Brandon Wai
7235 East Mercer Way, Mercer Island, WA 98040

Date: October 2, 2023

We are the structural engineers of record for this project. This letter lists the comments related to the structural design and what was done to address each comment.

S-2

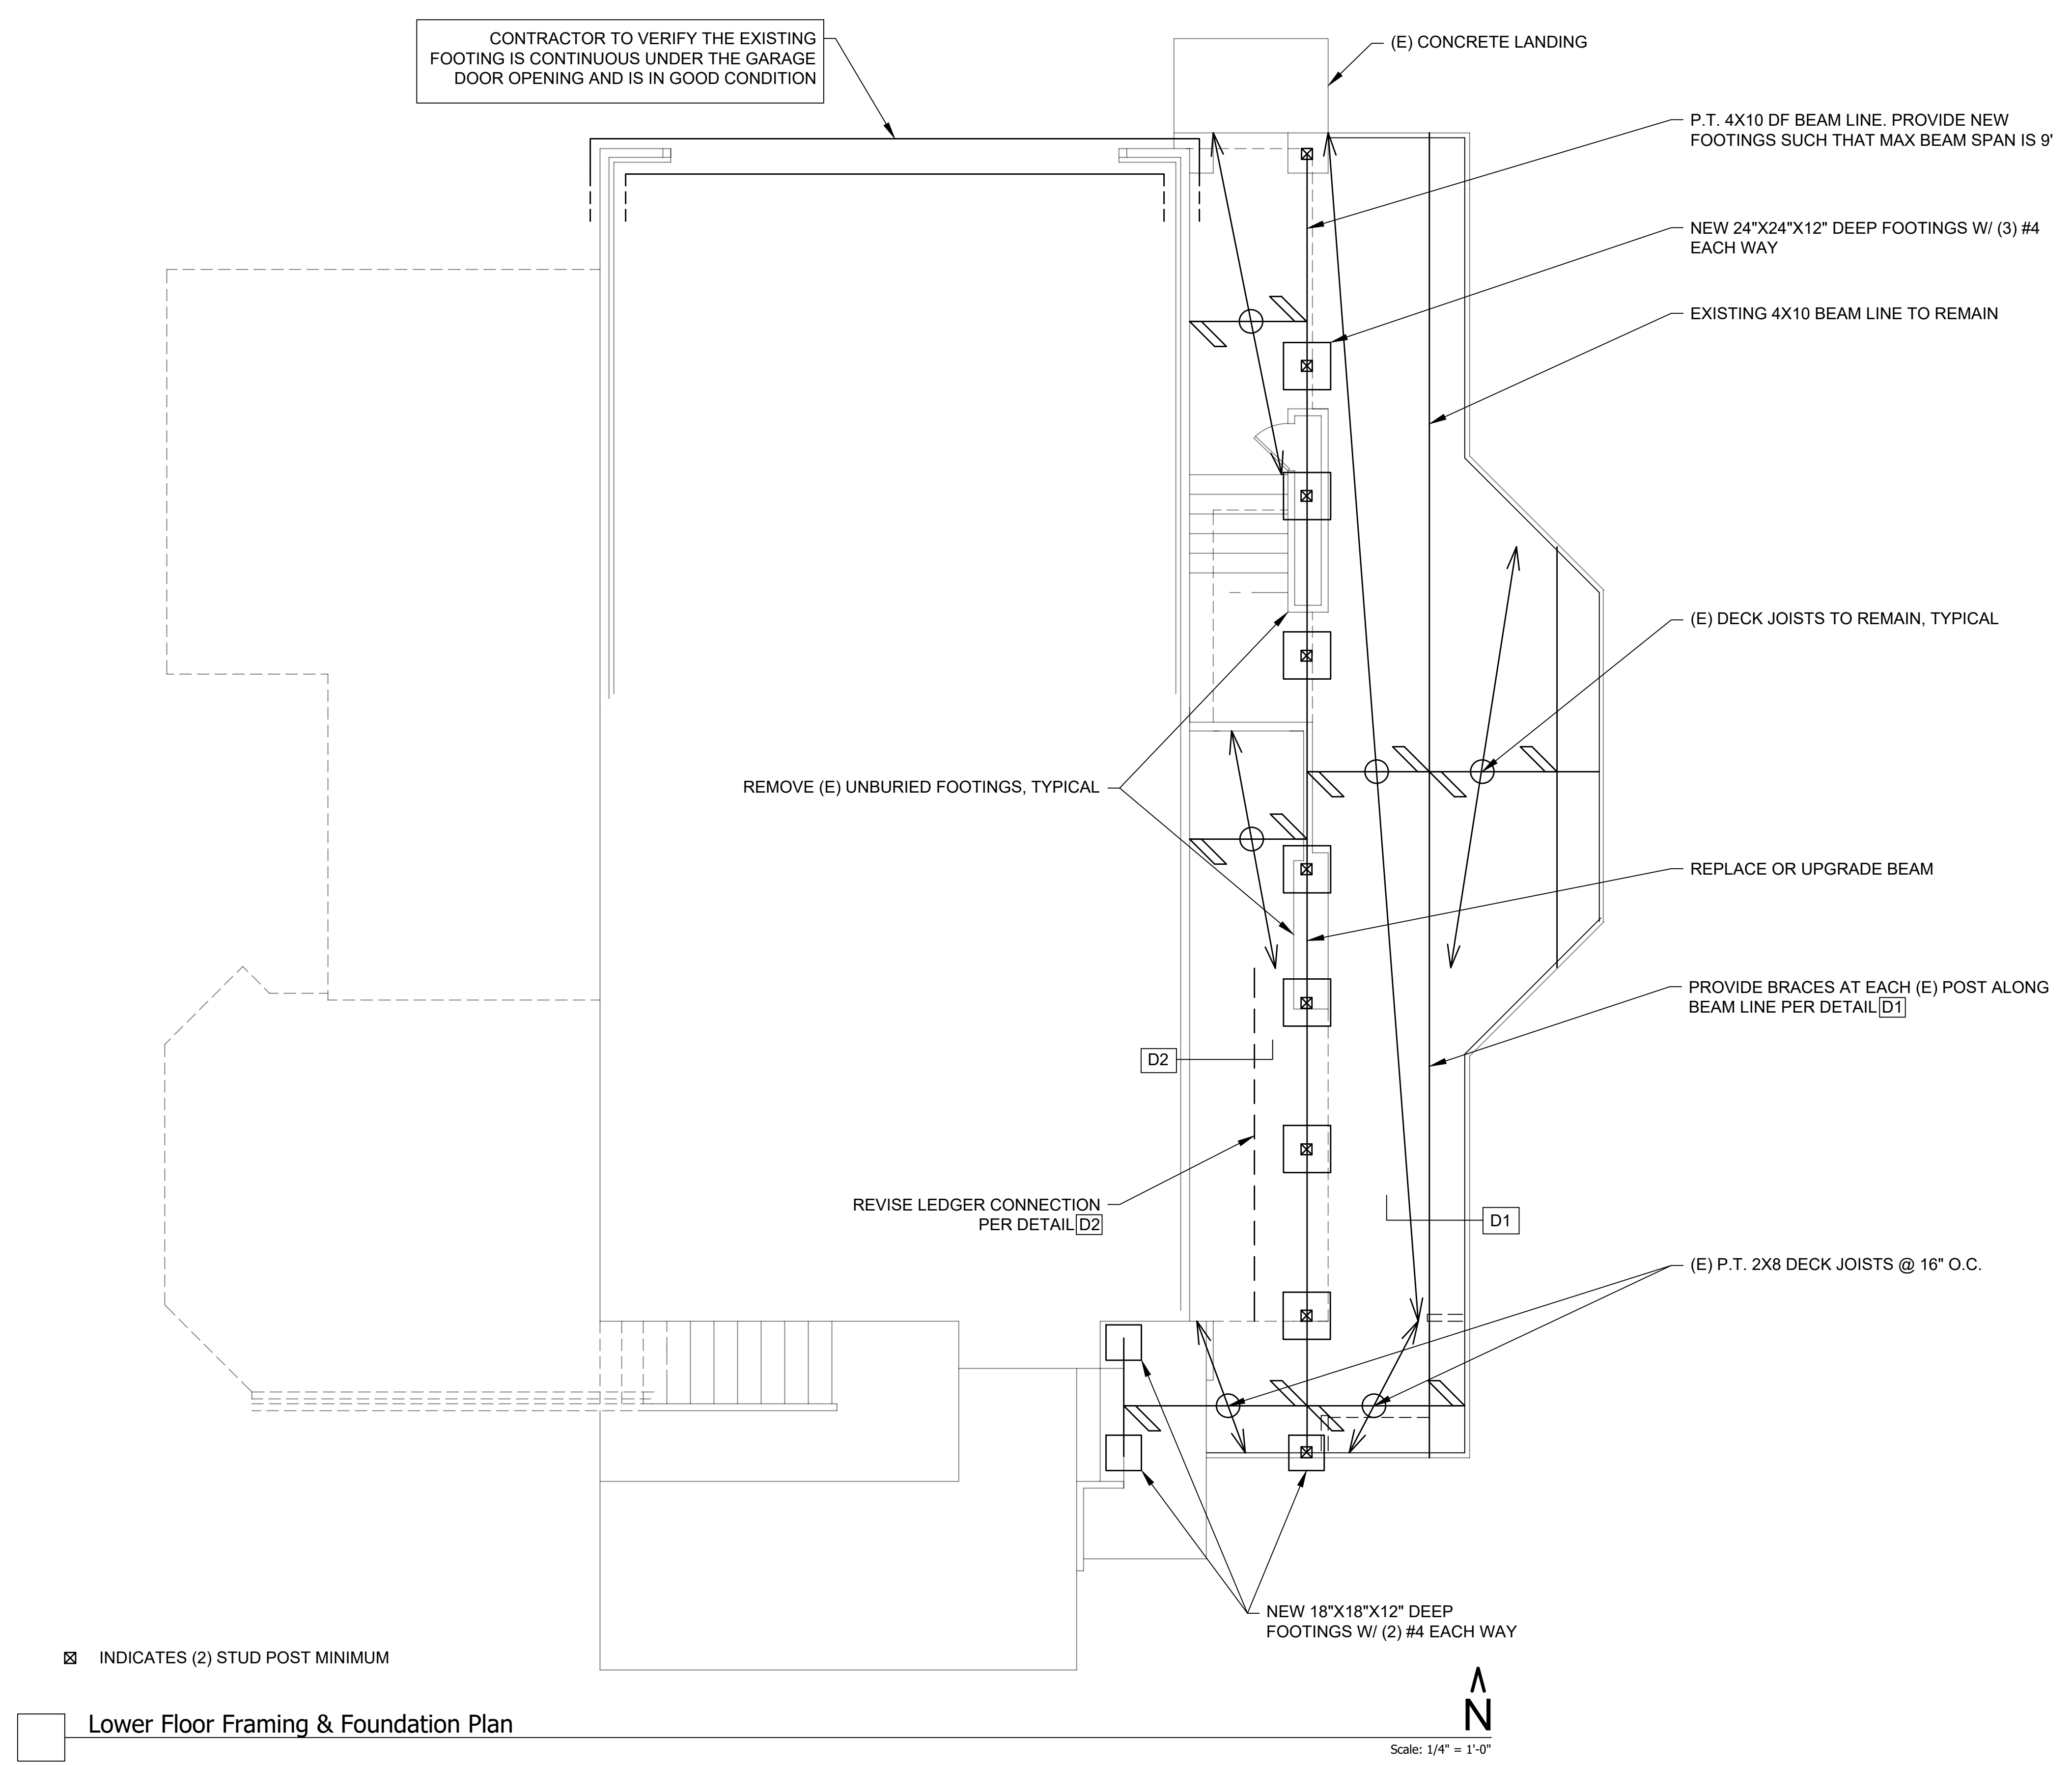
Geo-technical recommendations on pg3/4 describe recommendation of pin-piles since poor soil bearing capacity and seismic conditions. There is no section for conventional footing. Provide revised design, or provide narrative/calcs pursuit to pin-pile design. Then provide detail for this condition.

Sheet S-2 has been updated to call out pin piles per detail P1, which can be seen on sheet S-4. The structural calculation package has been updated to reflect the calculations for the pipe piles, on page F1.

S-2

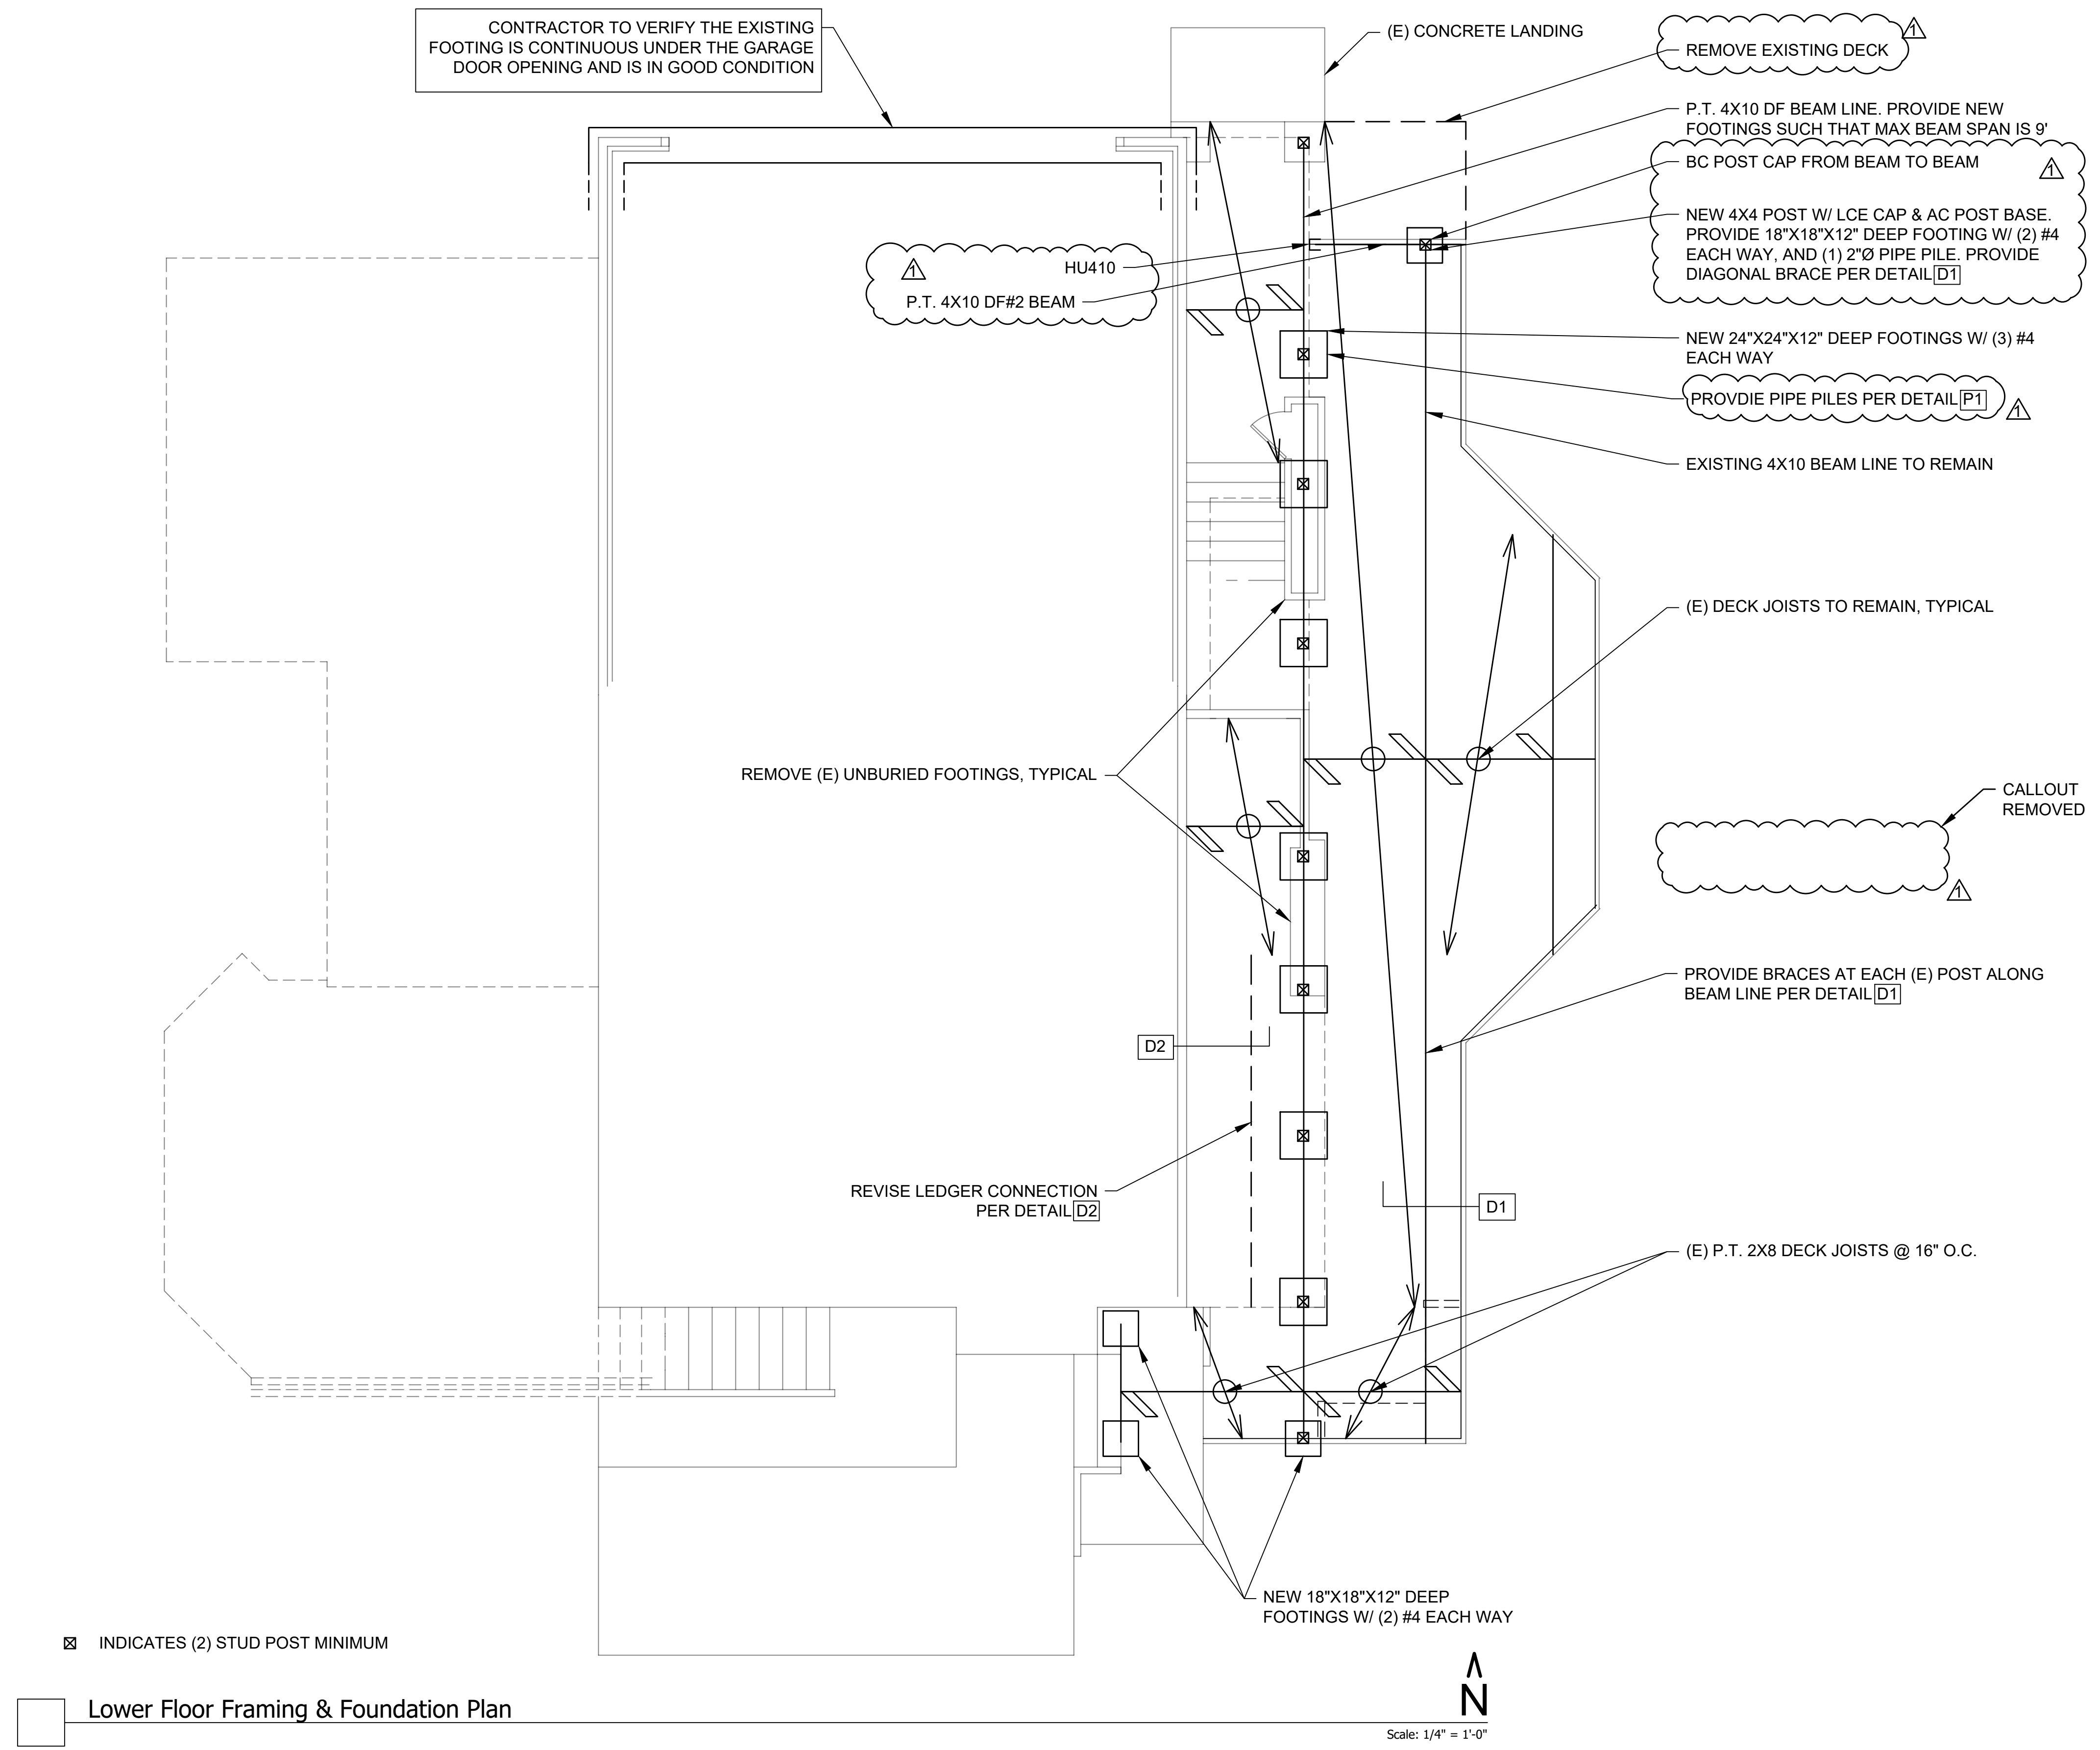
Specify a beam if required to be upgraded.

P.T. DF 4x10 Beam is called out along the beam line on sheet S-2. The callout “REPLACE OR CALLOUT BEAM” has been removed for clarity.
